CITY OF PORTLAND
STOP WORK NOTICE

July 3, 2001

RE: 74 Wilson Street
CBL: 016-C-001

An evaluation of the property at 74 Wilson Street revealed that the structure fails to comply with Section 107.1 of the Building Code of the City of Portland.
Construction Being Done Not In Accordance With Approved Permit (Installation of Deck, Removal of Bearing Walls)

SHEET NO. 2 OF 4 Revisd

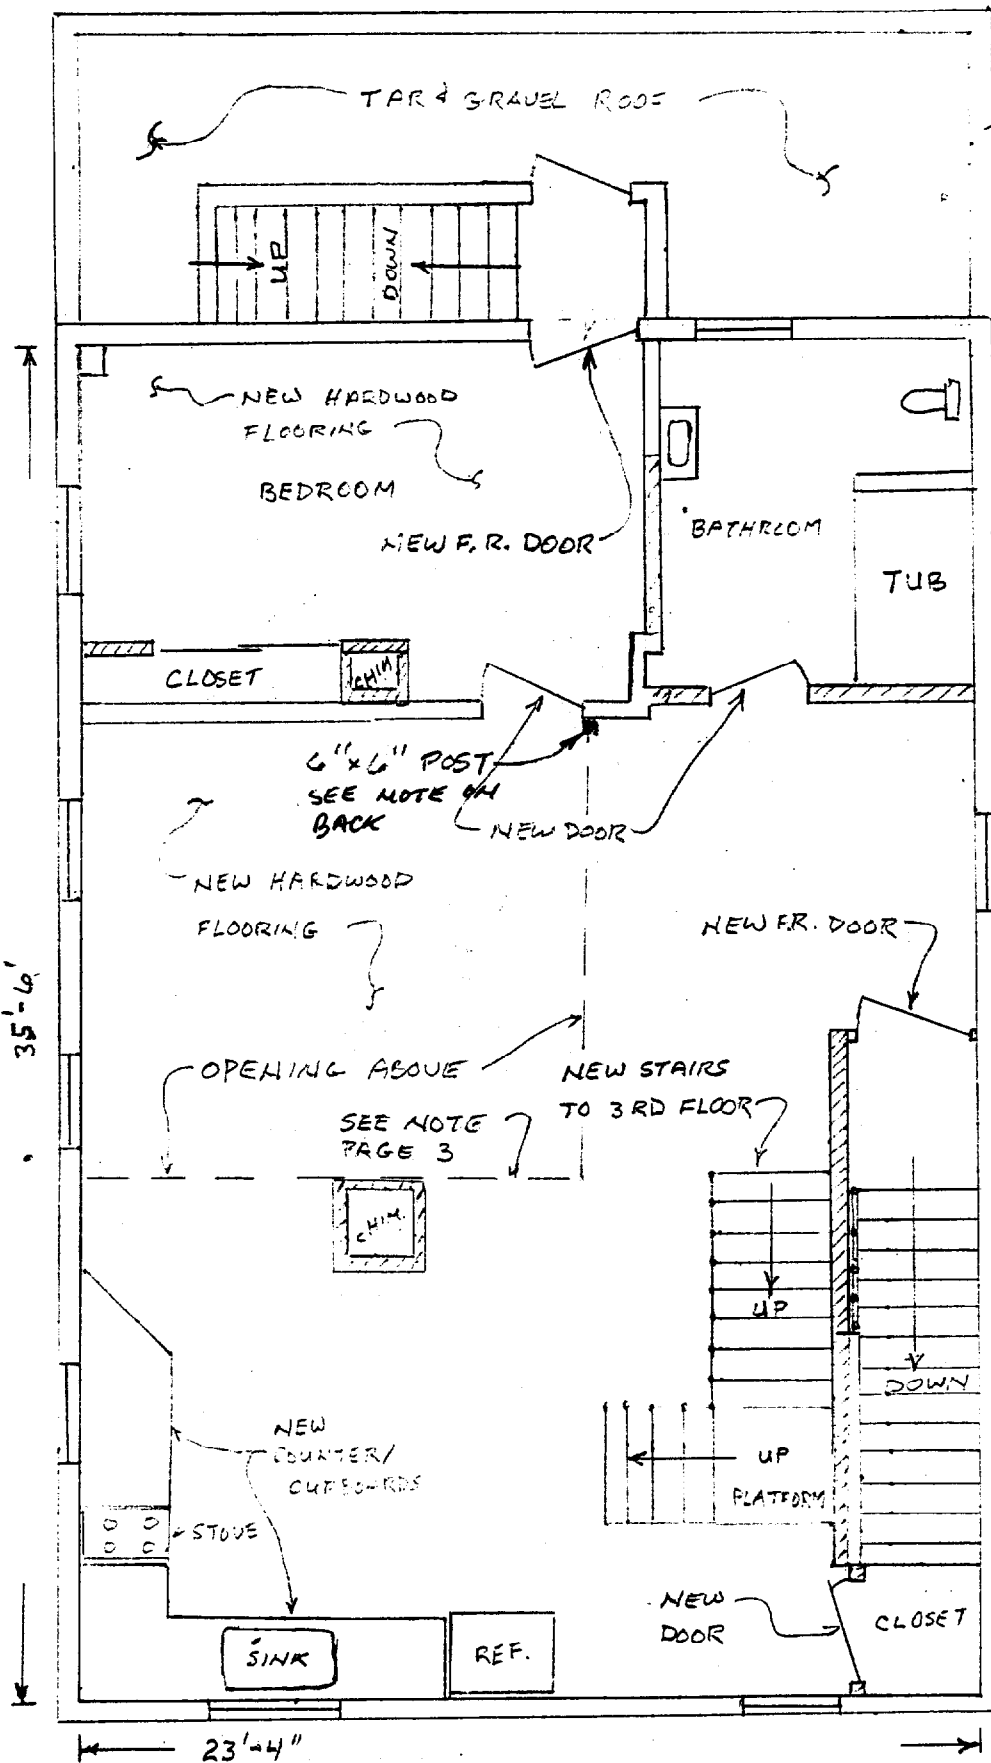
Construction shall not commence until such time as a structural engineer has reviewed work done thus far, and certifies that the changes made are structurally sound. Such certifications shall be submitted to this office for approval before work begins.
